From: [Trujillo, Timothy R, NMDOT](#)
To: [Cherne, Curtis](#)
Cc: "Verlyn Miller"; [Harmon Rita T.](#)
Subject: RE: Green Jeams Farmery Carlisle and I40
Date: Wednesday, October 15, 2014 11:35:07 AM

From: Cherne, Curtis [<mailto:CCCherne@cabq.gov>]
Sent: Wednesday, October 08, 2014 3:58 PM
To: Trujillo, Timothy R, NMDOT
Cc: 'Verlyn Miller'
Subject: Green Jeams Farmery Carlisle and I40

The Green Jeans Farmery is the site I discussed with you earlier. It is located at the northeast corner of Carlisle and I-40. I have attached a large portion (all could fit on the copier) of the conceptual plan.

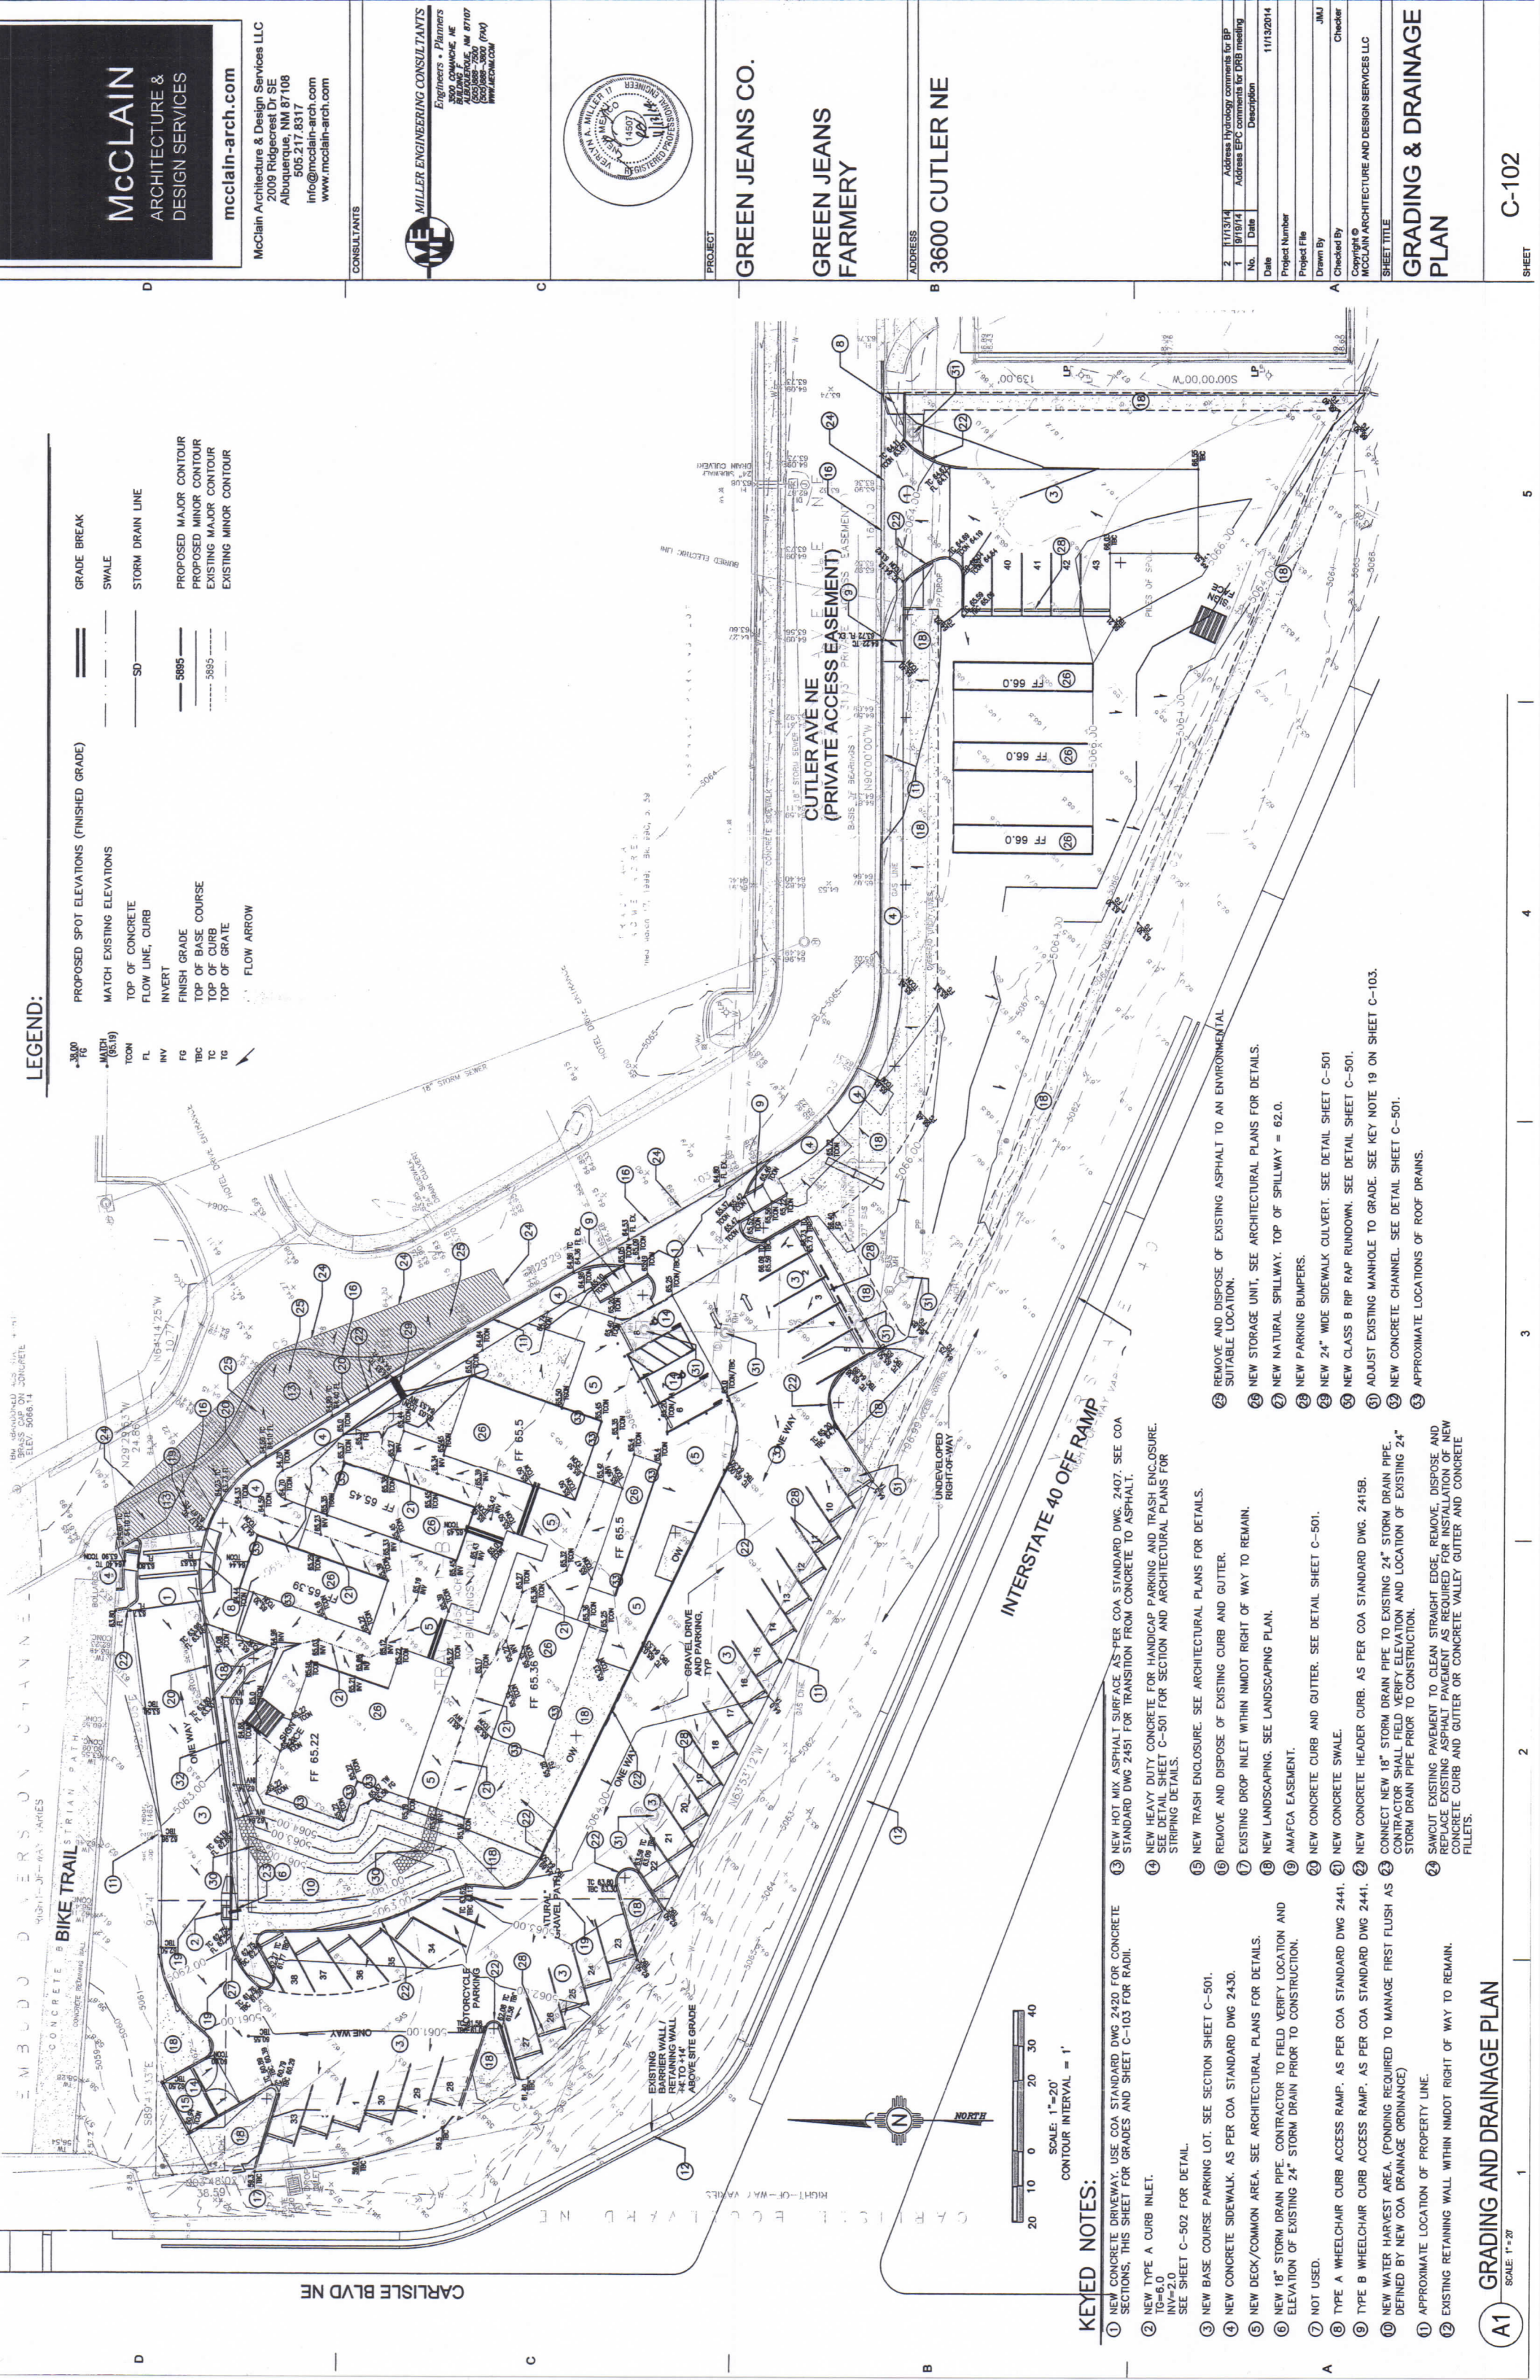
I agree with your comment on keyed note 10. The first flush pond would be more effective if it was collecting pollutants from parking lot and not the roof top where there are none. Is the swale in NMDOT ROW existing? I'm thinking about it from the maintenance perspective of having to access in-between the off ramp and the property.

The site is proposed to drain to an inlet located in the northwest corner of the plan, keyed note 17, per the drainage master plan for the area prepared by Chavez-Grievies in 2001 that showed this site could drain 7.5 cfs to the inlet, which is connected to a 36" storm drain that drains to the channel to the north.

Keyed note 3 is for base course parking lot. Keyed note 6 is for curb cuts to drain the base course area to the swale. I'm thinkin' they should not have curb and gutter, keyed note 7, along this edge so the area sheet flows into the swale.

Keyed note 10 is their first flush pond. They should adjust their flow arrows from the buildings to direct more water to this pond.
